KITTITAS COUNTY

MEMORANDUM

TO: Community Development Services
FROM: Taylor Gustafson, Environmental/Transportation Planner TG
DATE: August 9, 2019
SUBJECT: 2nd County Review of Final Plat LPF-19-0004 (Palomino Fields – Div. V)

**LCU, INC.**  
Surveyed by LMH Scale 1" = 300'  
Drawn by Tml/FCS Sheet 1 of 4  
Checked by FCS Project No. 18146

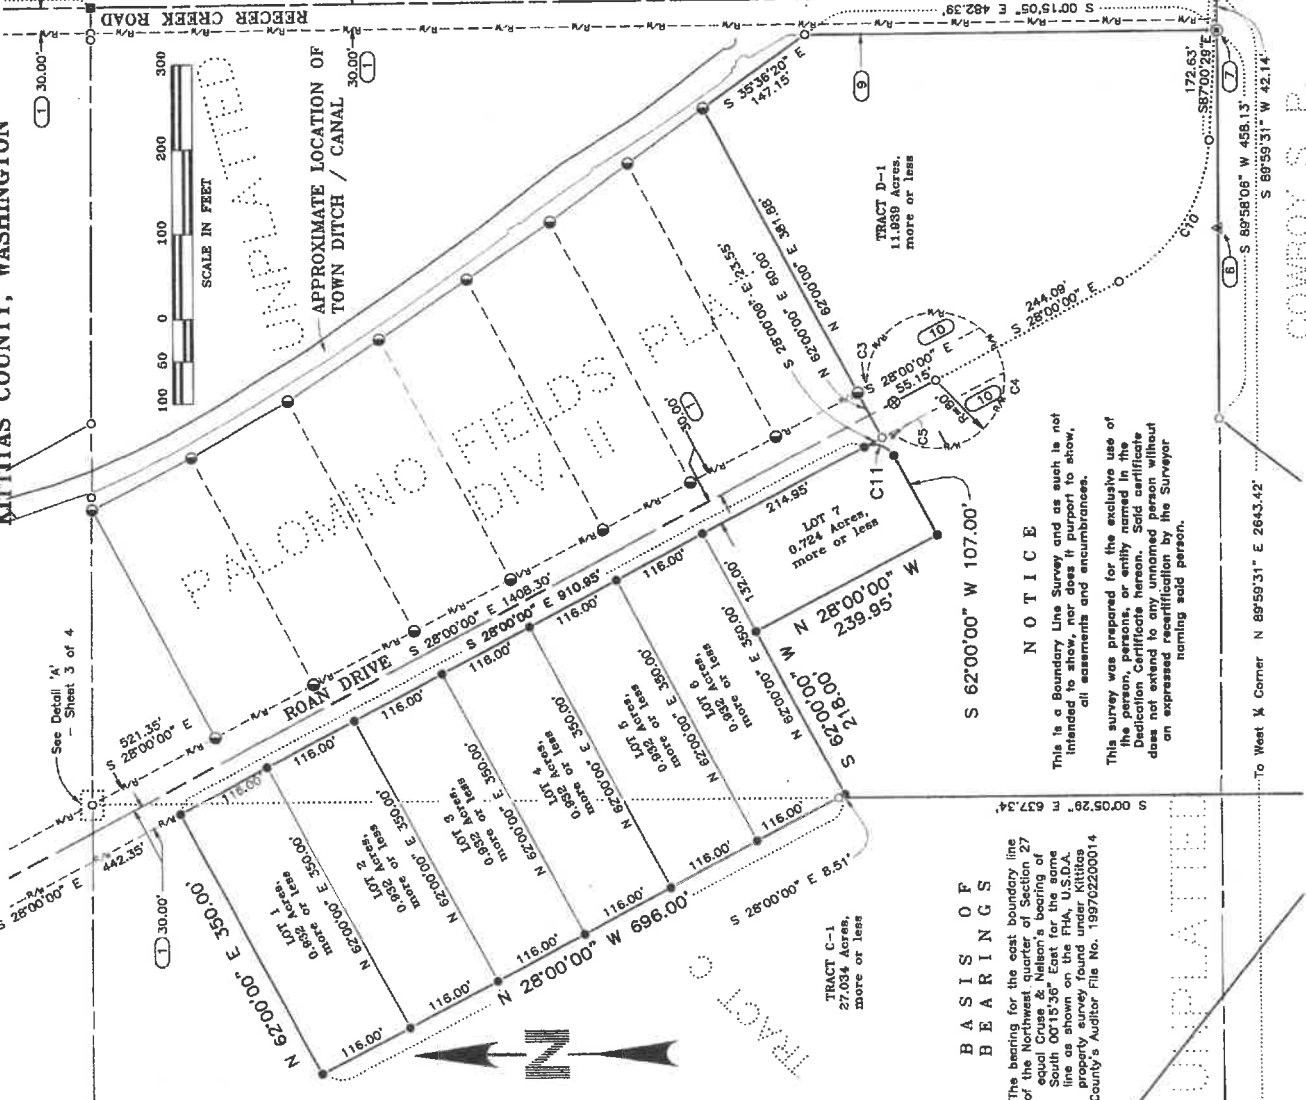
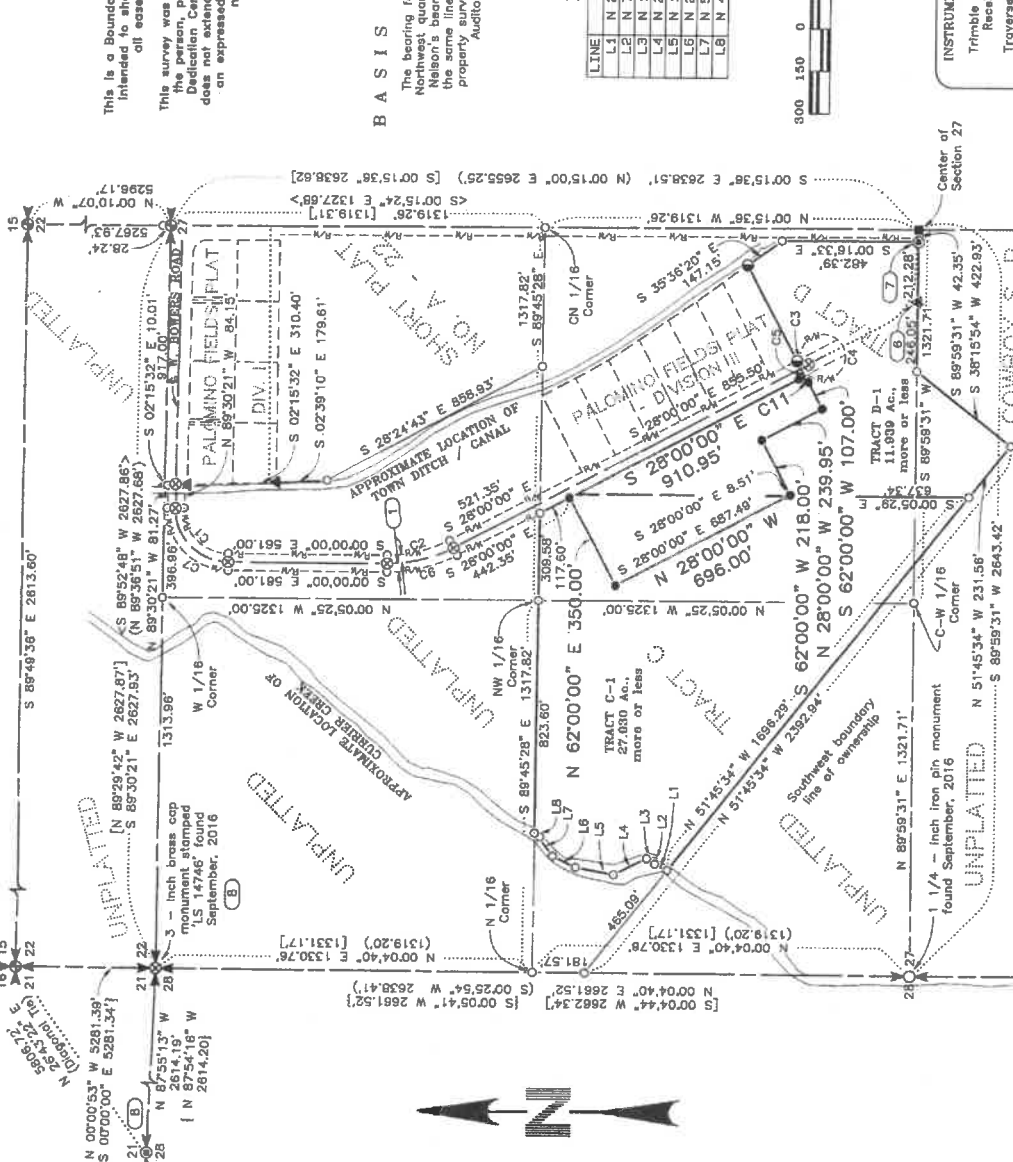
1. Cul-de-sac Radius is showing 80'. County requires 55'.
2. Cul-de-sac is showing currently as Right-of-Way. I believe the intent was for the cul-de-sac was to be temporary until further development occurs.

1. Some of the bearings and distances shown do not match closure report.
2. Some of the bearings and distances shown do not match record information of the parent parcel referenced as Palomino Fields – Division II.
3. Some of the bearings and distances shown do not match between pages 1 and 2.

**LCU, INC.**  
Surveyed by LMH  
Drawn by Tml/FCS  
Checked by FCS  
Scale 1" = 100'  
Sheet 2 of 4  
Project No. 18148

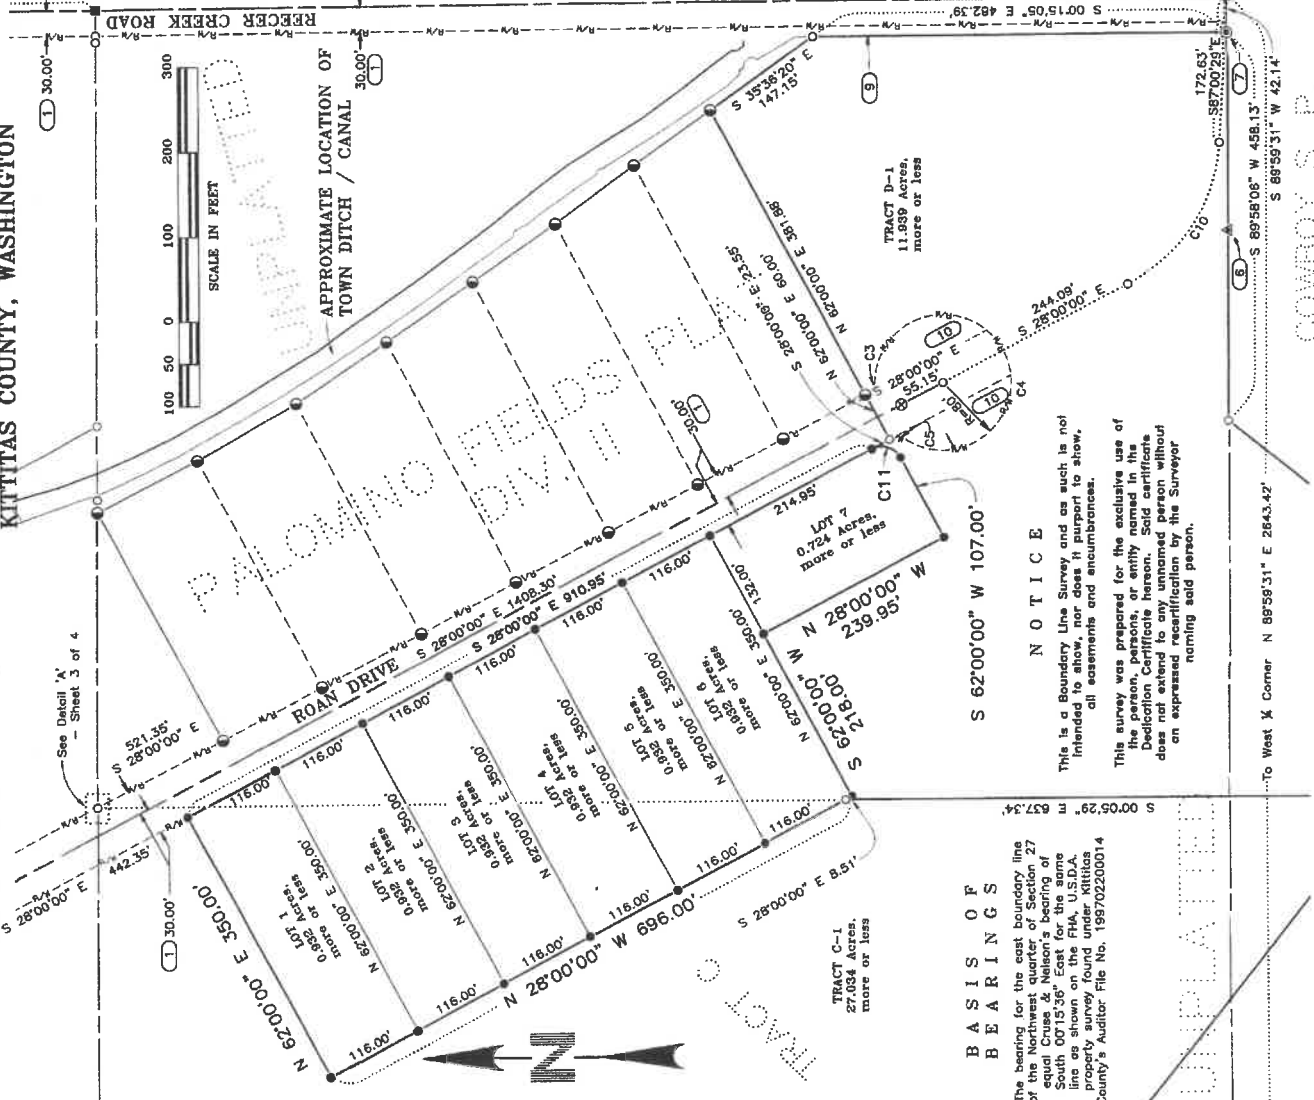
4. Some of the bearings and distances shown do not match closure report.
5. Some of the bearings and distances shown do not match record information of the parent parcel referenced as Palomino Fields – Division II.
6. Some of the bearings and distances shown do not match between pages 1 and 2.
7. The Note 10 reference located at the center of the cul-de-sac is not addressed under plat notes.
